**From:** Tim Screen  
**Sent:** 07 February 2019 10:56  
**To:** Andrew Lewis  
**Subject:** FW: Planning application No.18/00435/DISC: Parcels B4A & B4B, Heyford Park.  
**Attachments:** B.0285\_119D Detailed Soft Landscape Proposal B4A[1].pdf

Further to my response of 21.11.2019 re: the tree root barriers, I confirm that the enclosed Detailed Soft Landscape Proposals are now acceptable.

**Subject:** RE: Planning application No.18/00435/DISC: Parcels B4A & B4B, Heyford Park.

Window Style - Type 1
3 bay with 3 top openers

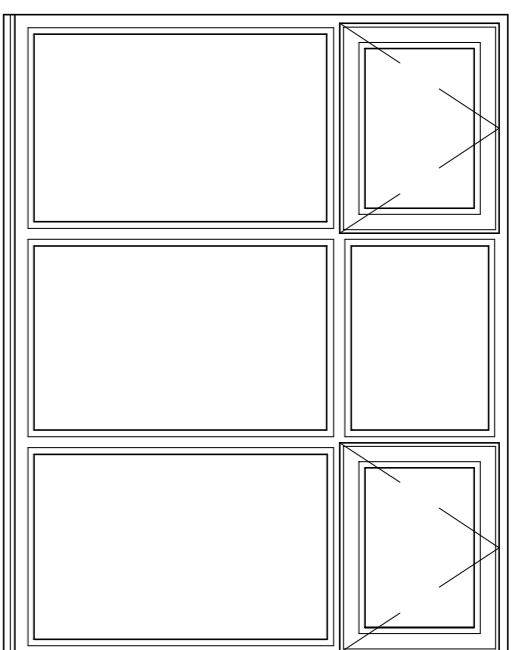
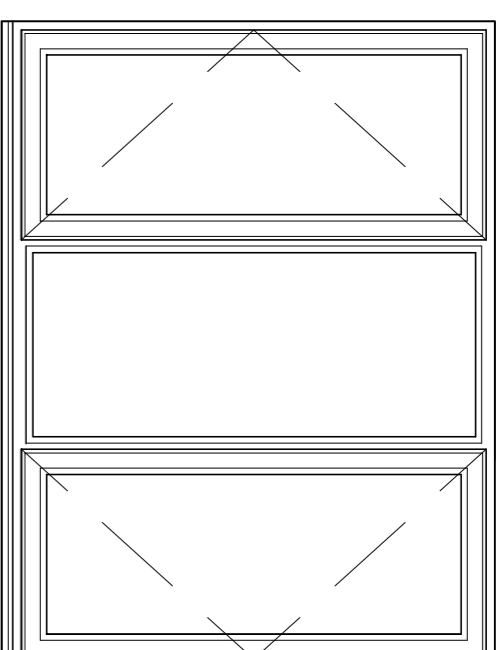
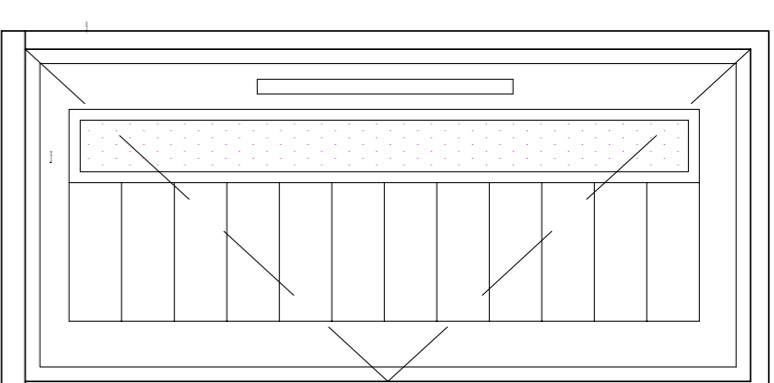
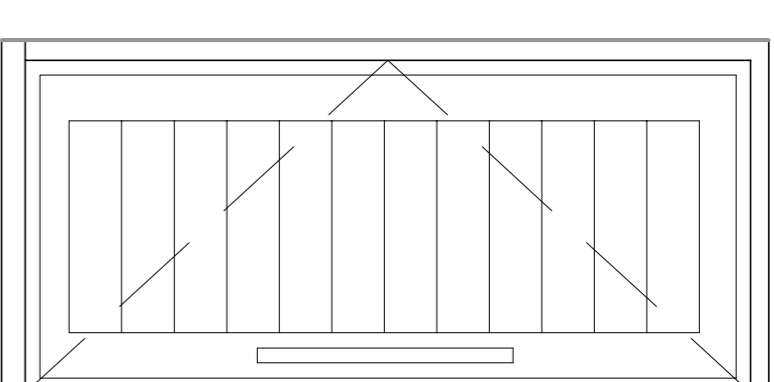
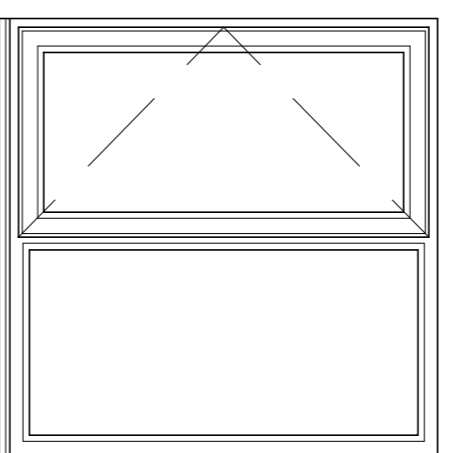
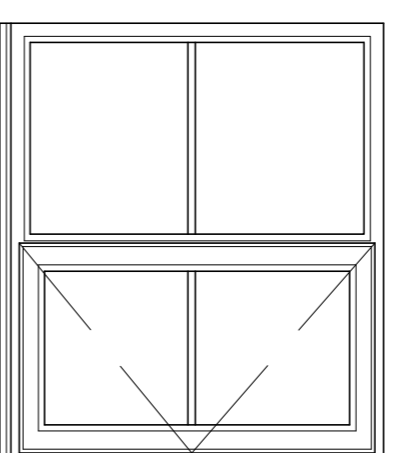
My conservation officer also wonders if the window frames could be metal rather than upvc. Can we clarify the colour?
